DRB Project Case #: 1006956

Subdivision Name: NORTH CARLISLE TRACTS 2A & 2B

Project Name: NORTH CARLISLE ADDITION

RE: Tract 2 & 4, North Carlisle Addition

**PLAT OF
TRACTS 2-A AND 2-B
NORTH CARLISLE ADDITION
WITHIN SEC. 2, T. 10 N., R. 3E.,
CITY OF ALBUQUERQUE, BERNALILLO COUNTY, NEW MEXICO
DECEMBER, 2007**

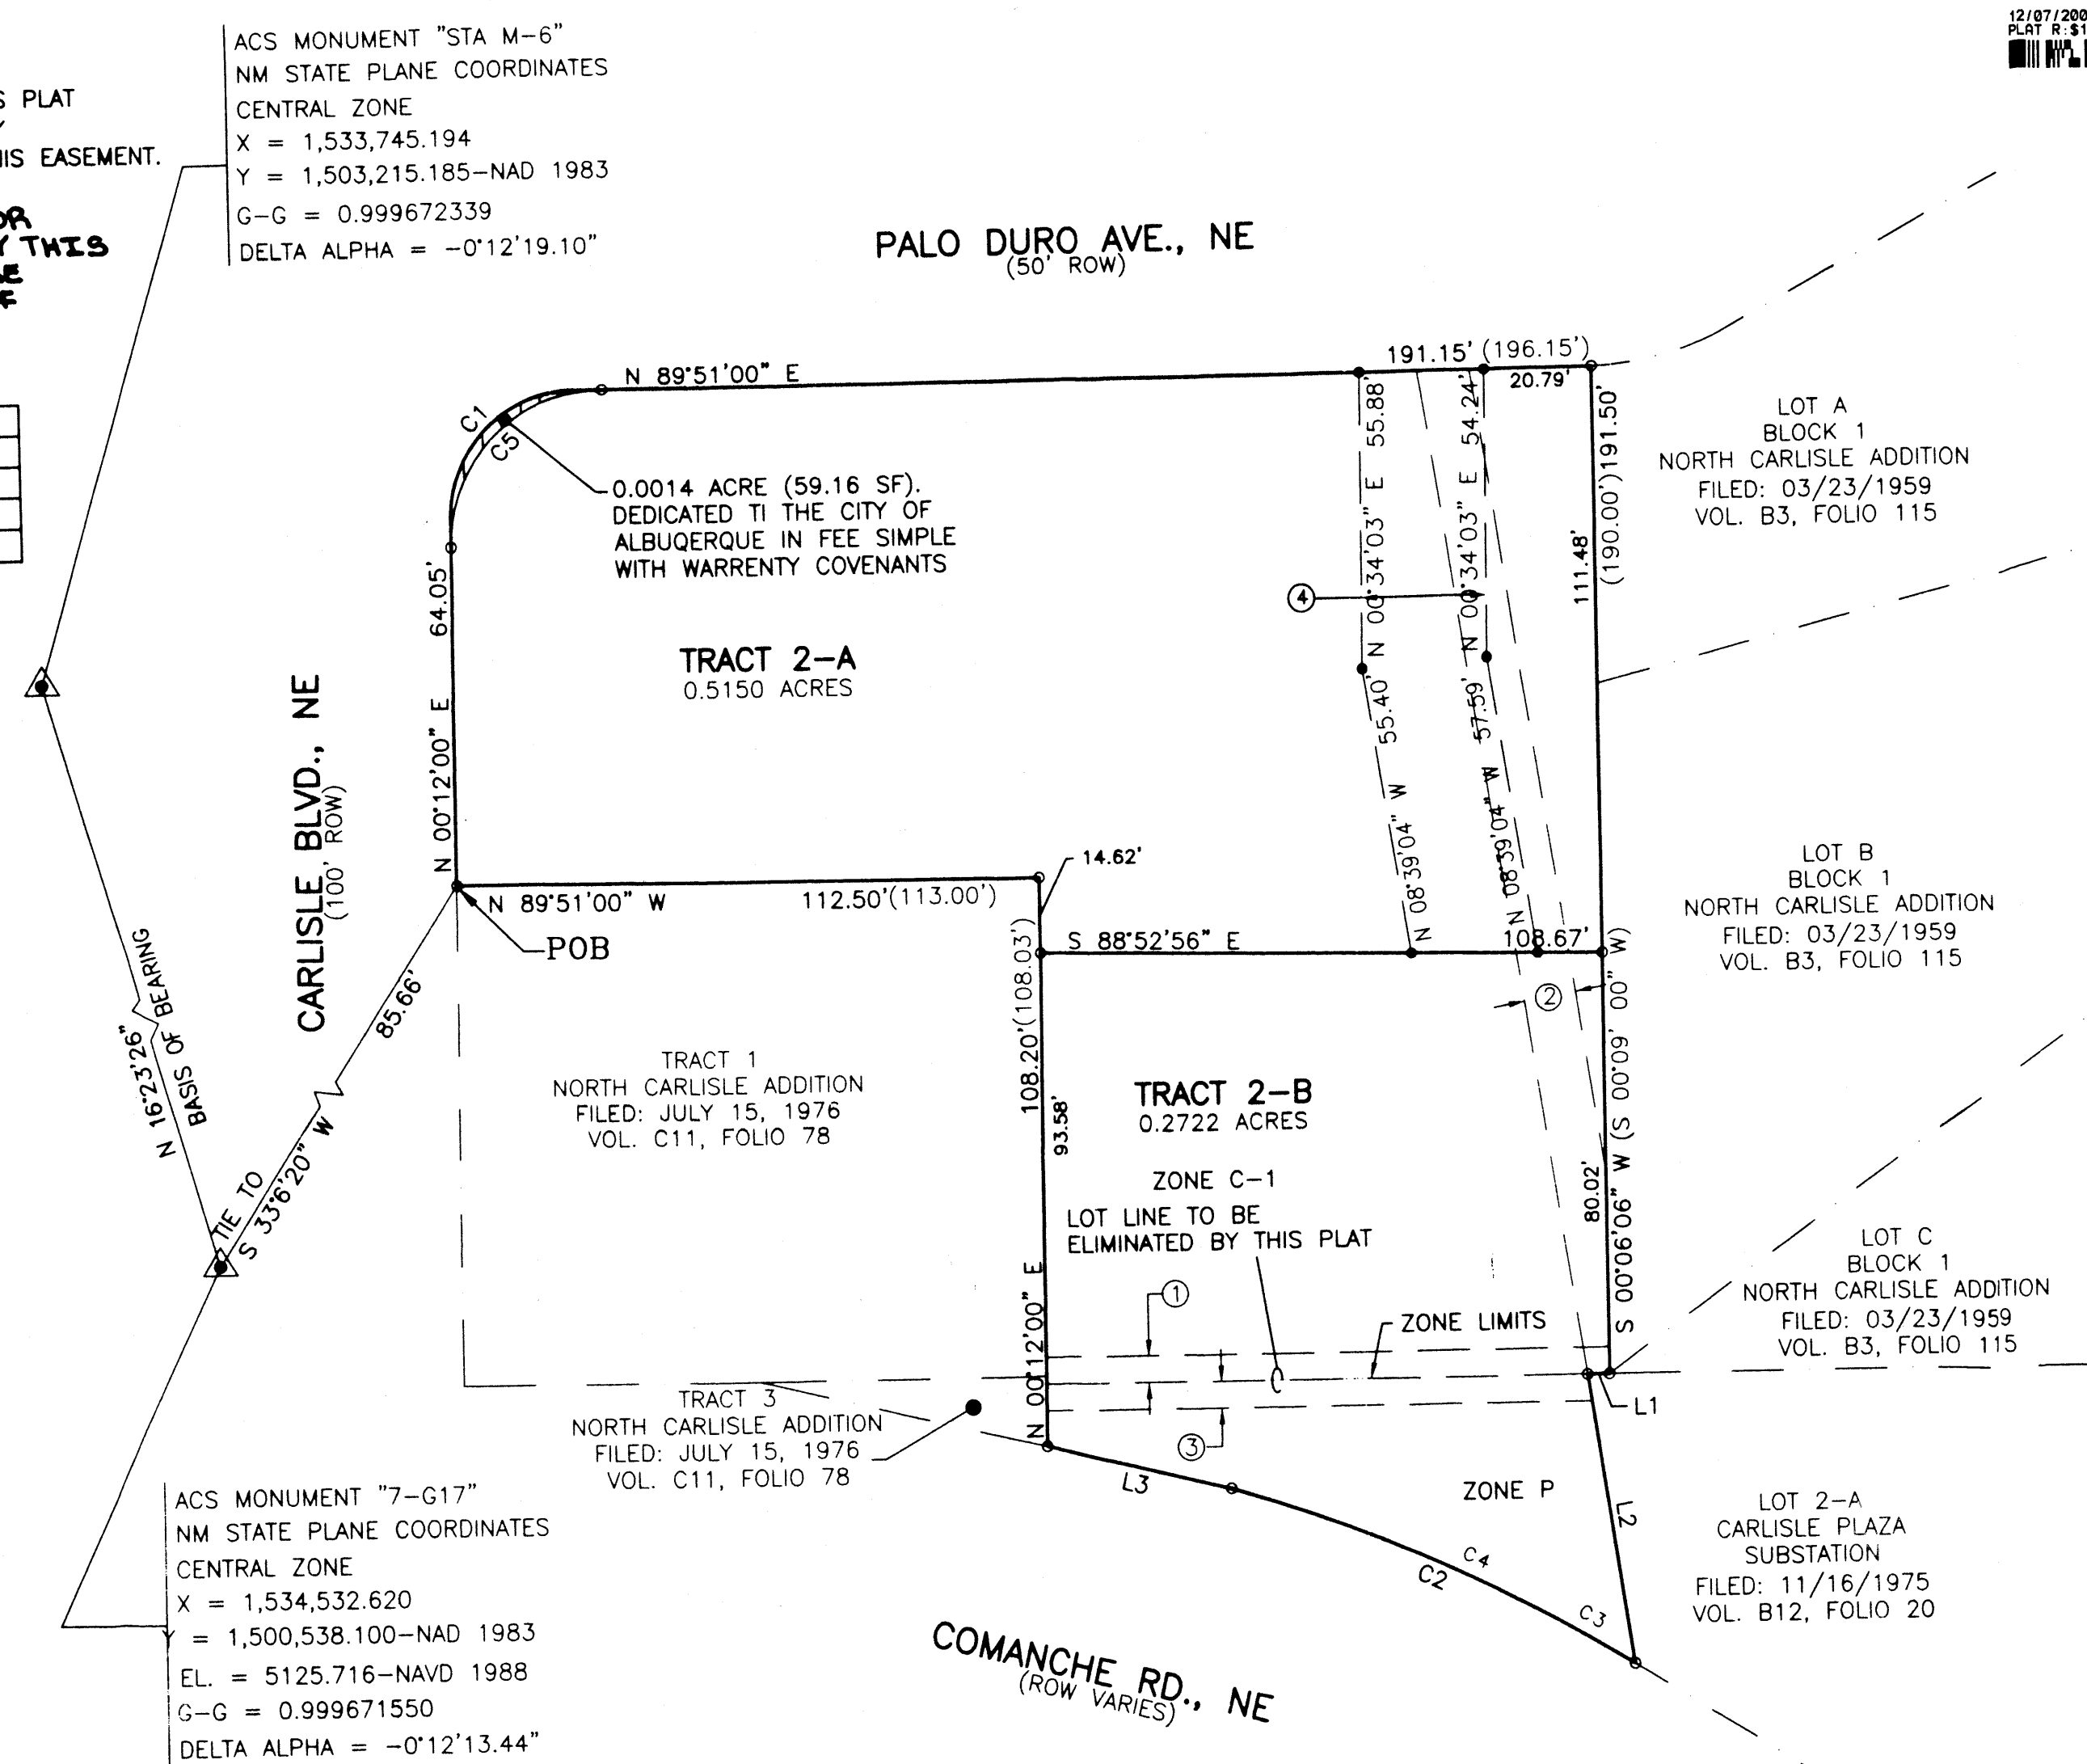
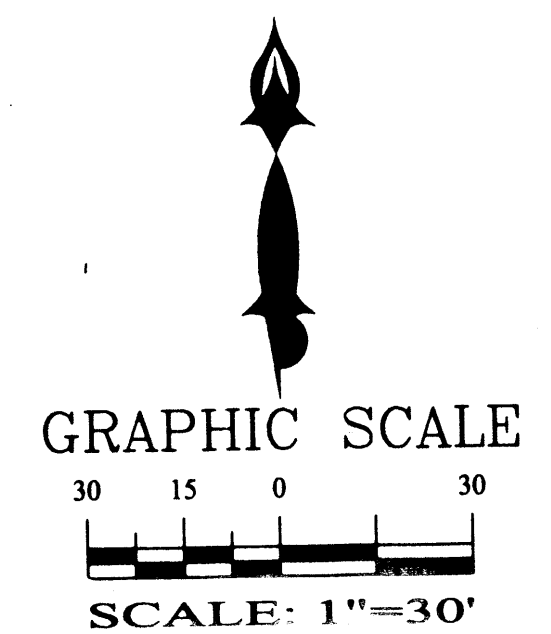
TRANSPORTATION: dedicate 30' radius
@ Carlisle + Palo Verde

**PLAT OF
TRACTS 2-A AND 2-B
NORTH CARLISLE ADDITION
WITHIN SEC. 2, T. 10 N., R. 3E.,
CITY OF ALBUQUERQUE, NEW MEXICO
NOVEMBER, 2007**

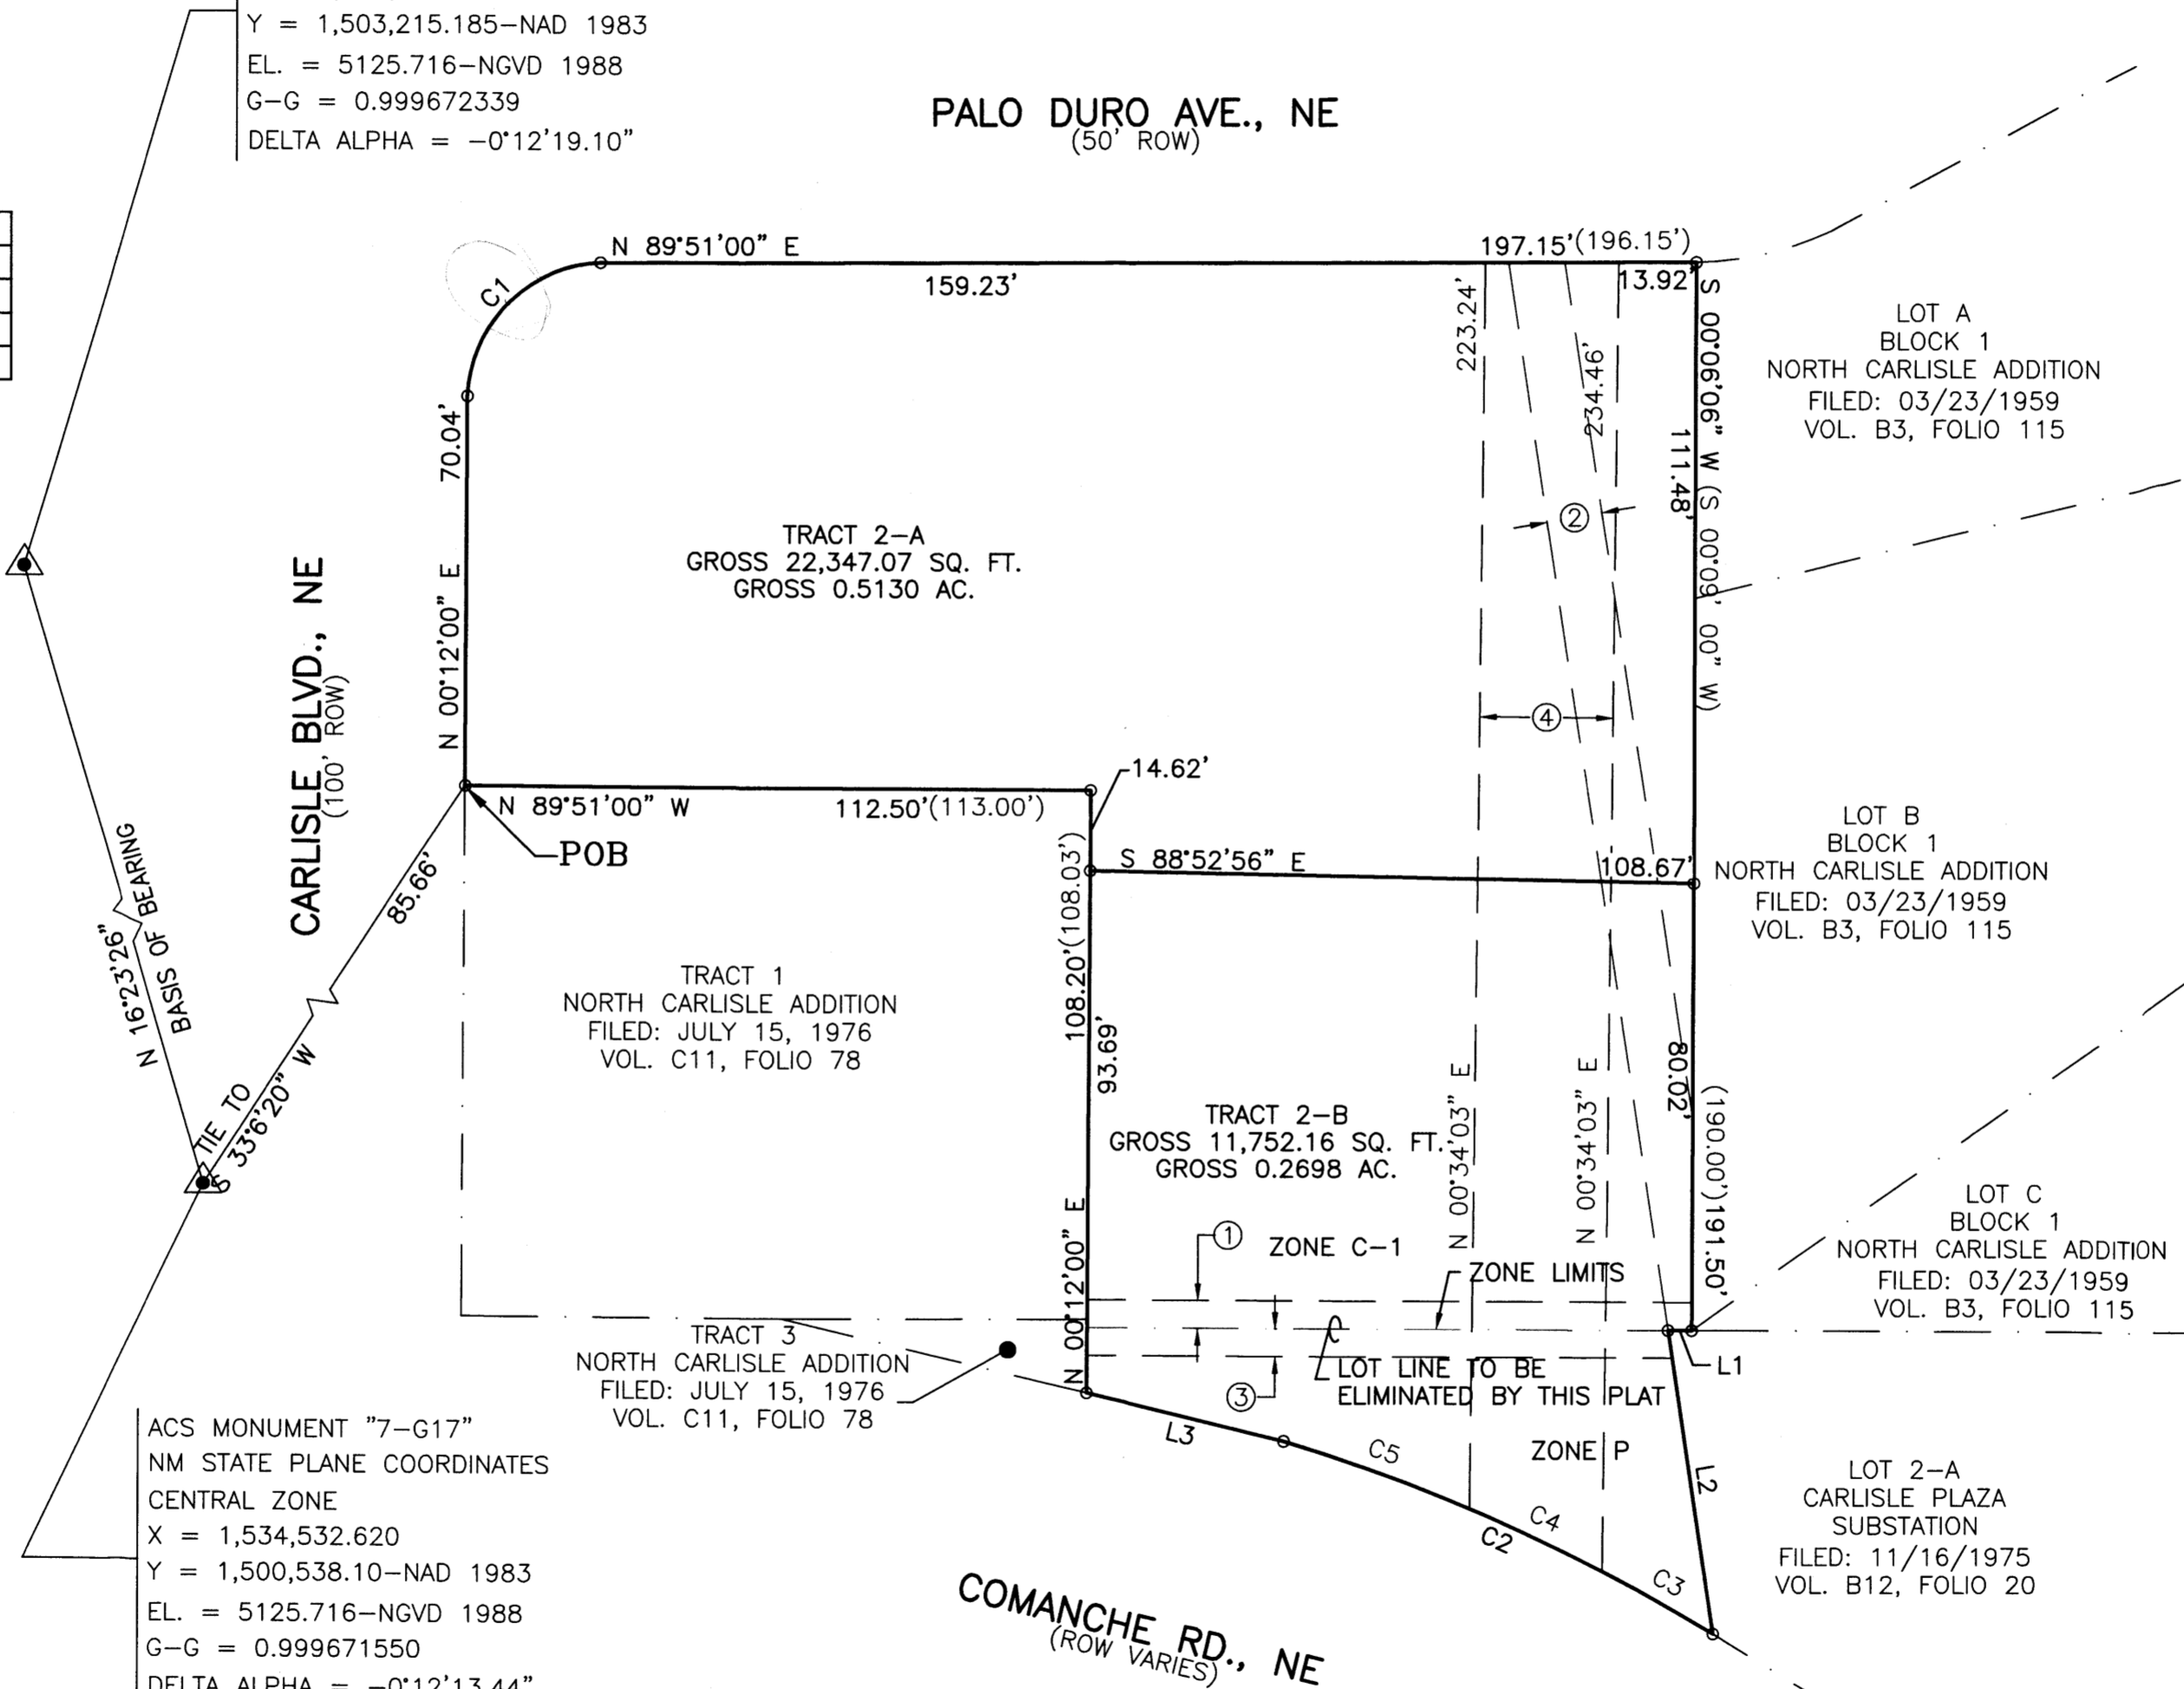
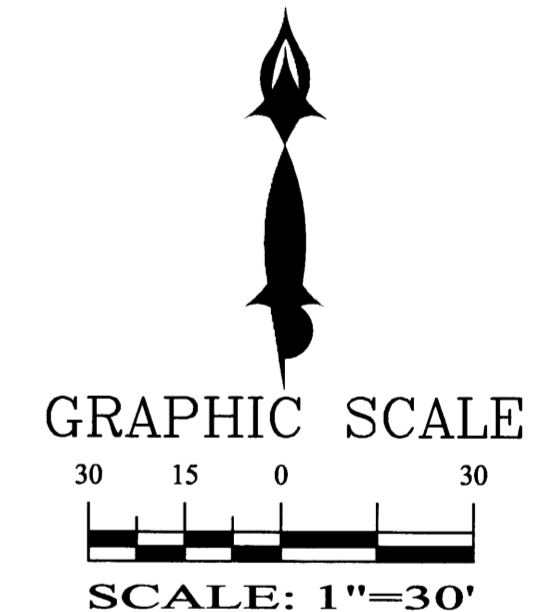
Certification is needed that the existing building conforms to the City's Building Code regarding the proposed lot line, and with the Zoning Code regarding on-site parking for each proposed lot.

A Subdivision Note consistent with Section 14-14-4-7 (B) of the Subdivision Ordinance regarding solar collectors is required.

attached to application
shown on exhibit
Comanche
Provide an exhibit for Carlisle Blvd and Palo Duro Ave showing the location of sidewalk and defining the distance from face of curb to the property line.
Per the Development Process Manual, Table 23.3.3, the right of way at the intersection of a minor arterial and a local roadway requires a radius of 30 feet

City Surveyor's review and approval are required for Preliminary and Final Plat approval.
Need cross-lot drainage easement.
